From: Simon Davis
Sent: 22 August 2022 12:25
To: Peter Cleveland [REDACTED]
Subject: RE: Y/53/22/DOC

Subject: [EXTERNAL] RE: Y/53/22/DOC

*The construction does not appear to have been carried out in accordance with the design, in addition there are still elements of the construction which are wholly reliant on the contractor's information rather than an independent verifier. As a result, **we would not recommend Discharge of Conditions** until the following information has been provided and following points have been addressed and approved in full.*

Scale	NTS	Date	06.08.21
Drawing No	E24121_13a	Rev	-

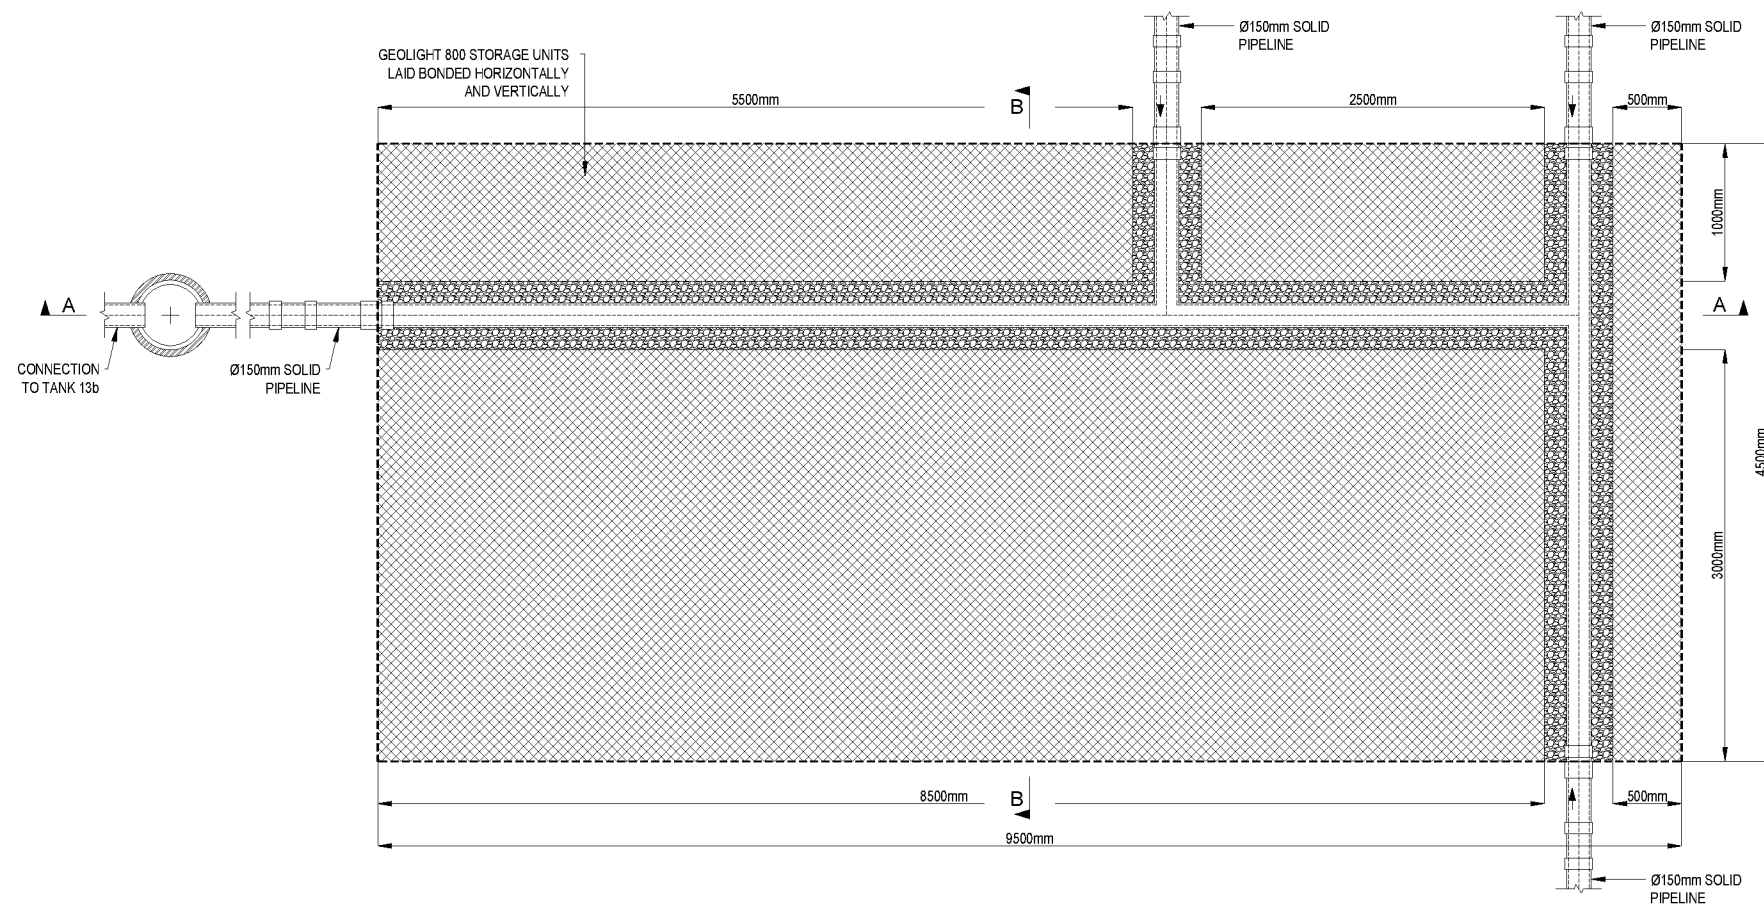
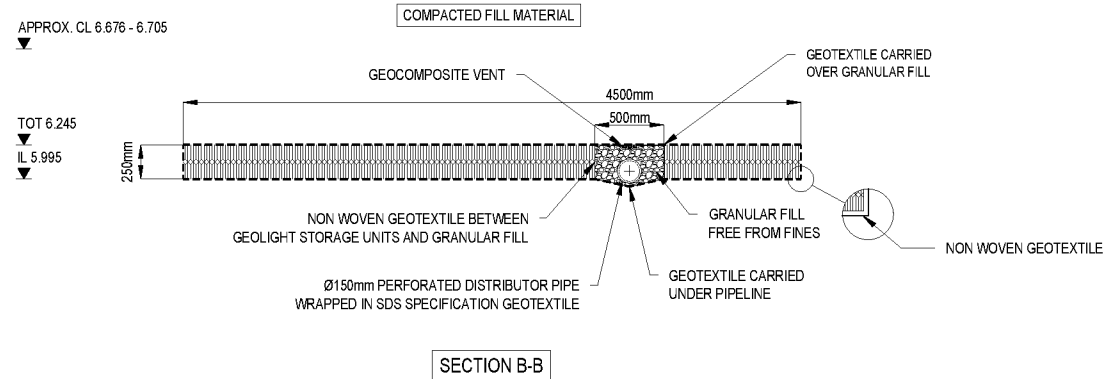
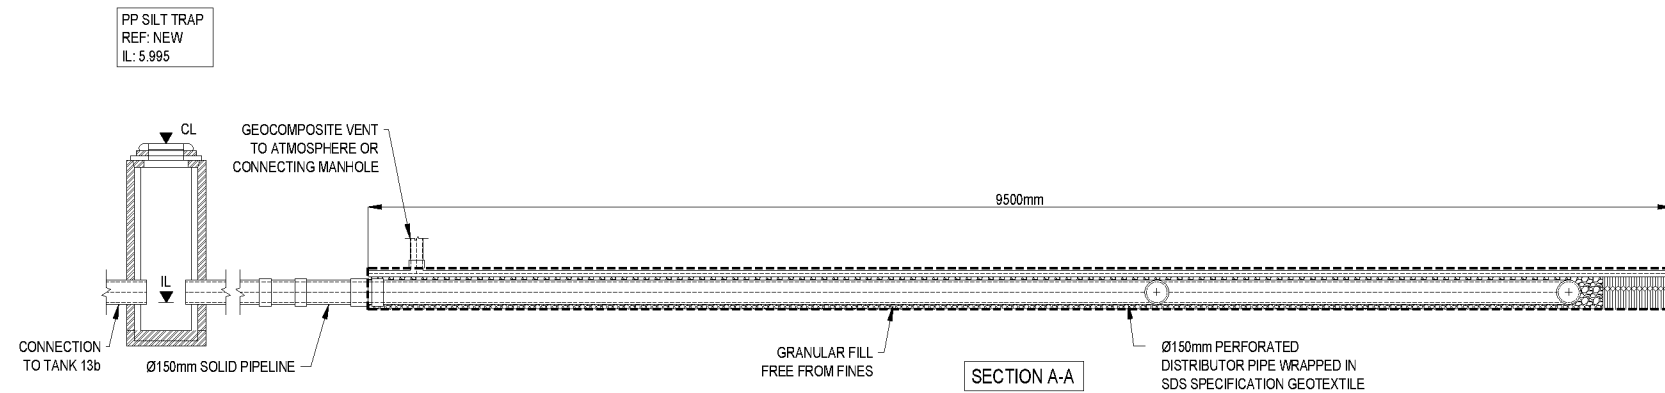
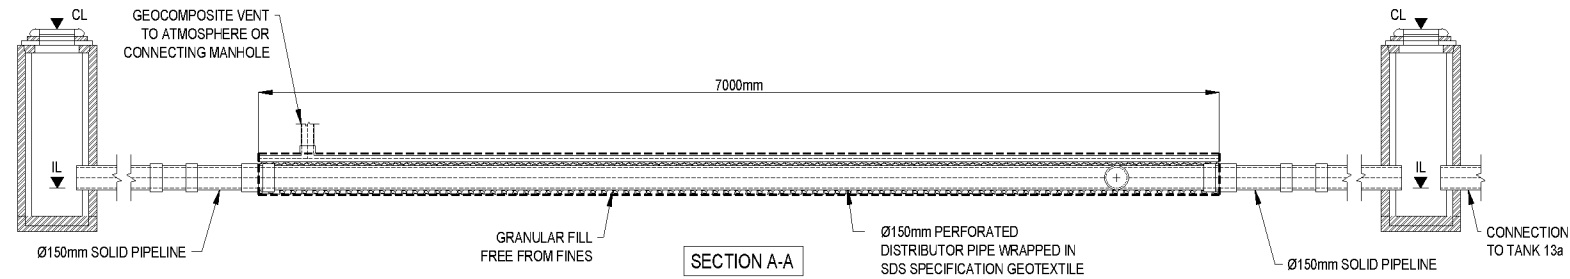
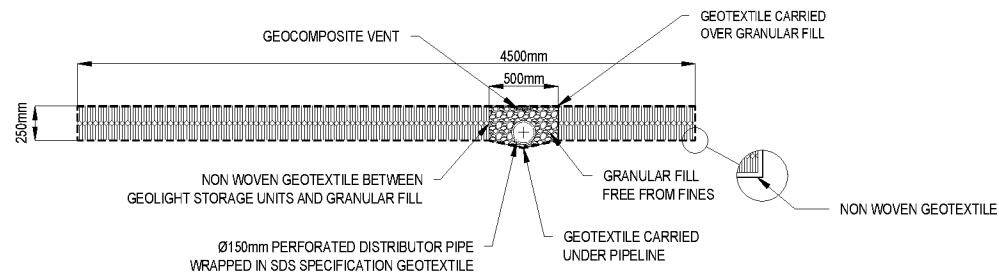
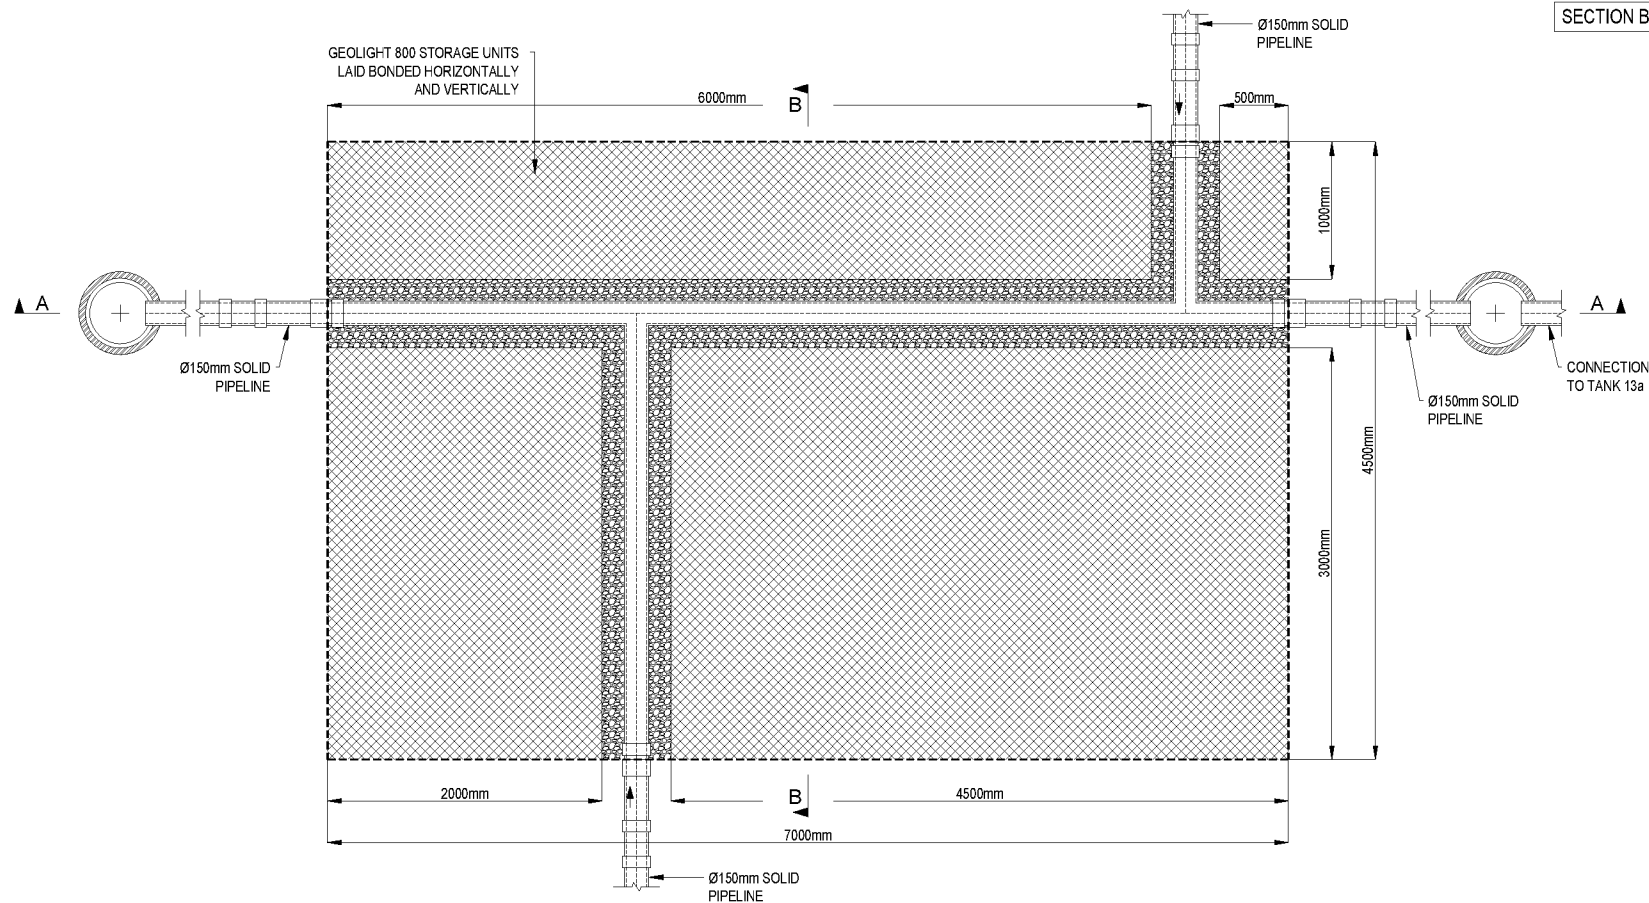
- *Checking and remediation of the poorly constructed sediment traps (assuming they are installed as photographed). The sediment traps should be installed as per the submitted drawings. These photographs show several defects in construction including square cut outs used to house round pipes, cracked rims and plastic, the use of unapproved materials within their construction, rubble filling the base (which visually cannot be confirmed to have been lined) and concrete which appears to have been used as a sealant and is partially blocking one pipe outlet. None of this appears on any of the approved drawings.*
